From: Daun Johnson
Sent: 27 April 2022 16:29
To: Planning.Responses
Subject: FW: Planning Application BN/16/22/PL - Trees

From: [REDACTED]
Sent: 19 April 2022 11:22
To: 'planning@arun.gov.uk' <planning@arun.gov.uk>
Subject: Planning Application BN/16/22/PL - Trees

I refer to my objection letter dated 5 April 2022 (08/04/2022 on the planning website) regarding misleading information submitted by the applicant in respect of trees on the proposed development site.

4 NO. 3 BED DWELLINGS
PROPOSED STREET SCENE AT

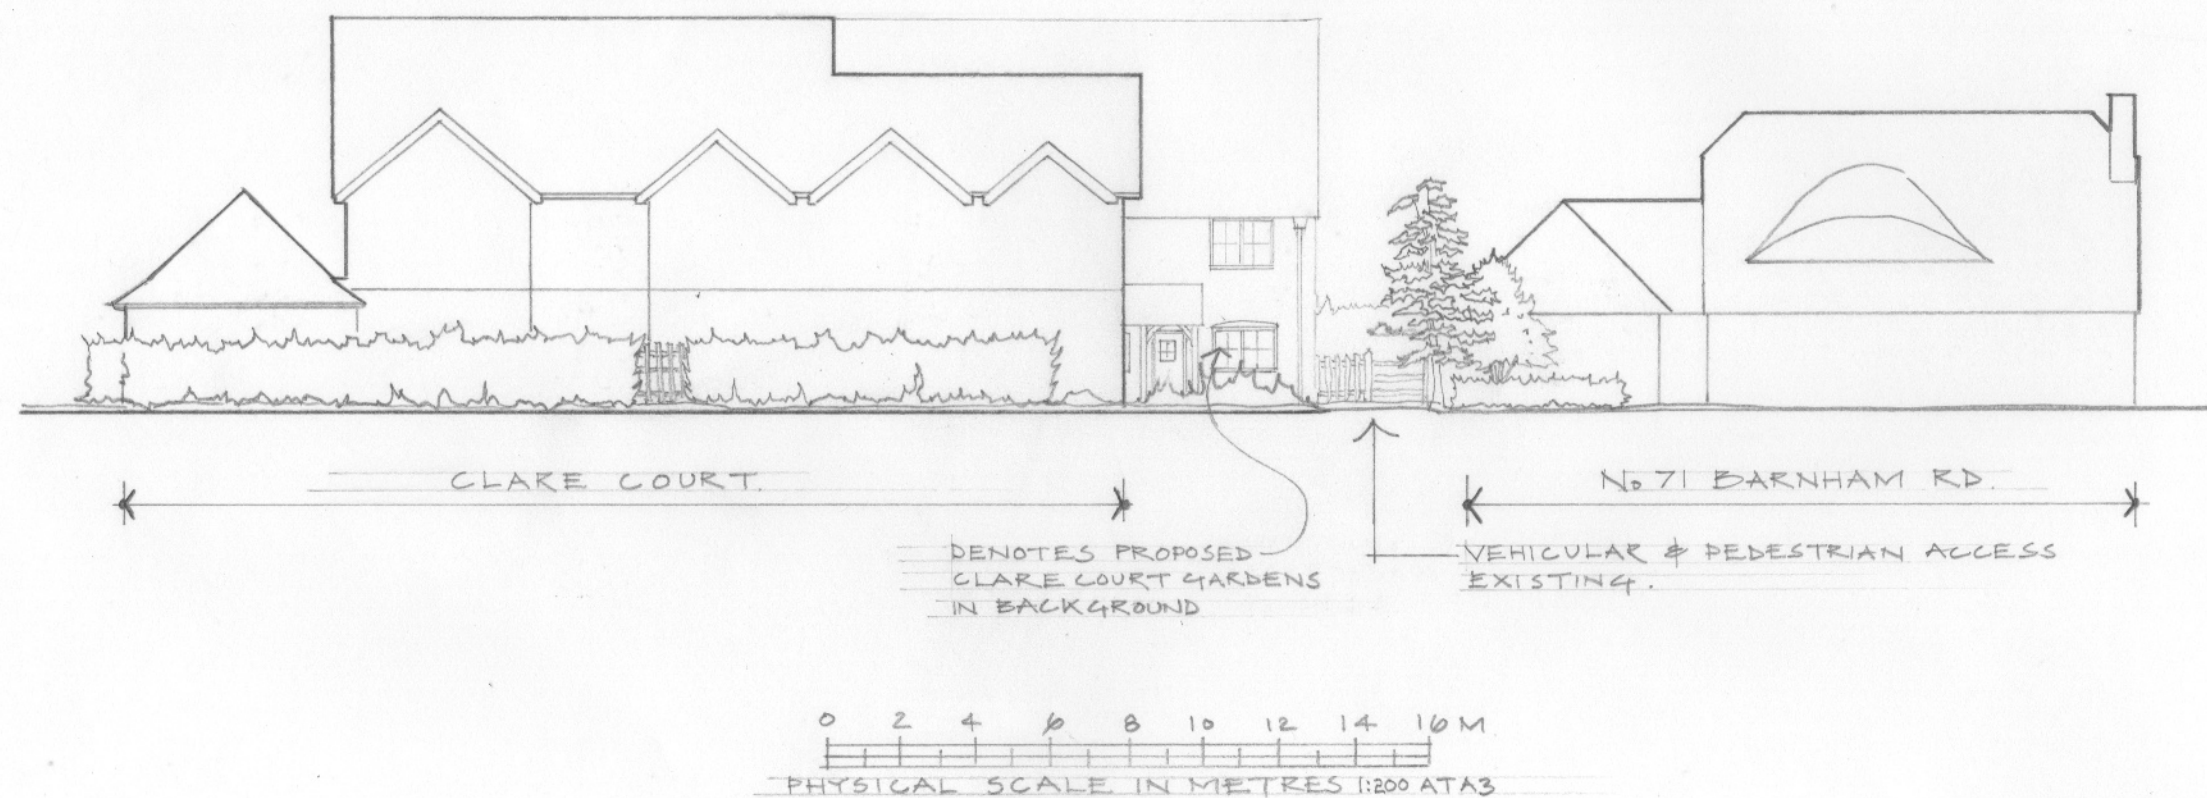
Exhibit B shows the damage already done to the Barnham street scene – and incidentally blows a hole in the ridiculous claims in the Pre-Application Advice and in the Planning Statement that the proposed new houses would not be visible. The whole row of semis will be manifestly visible as a misplaced oddity, out of alignment and totally incompatible with the other houses along this stretch of Barnham Road.
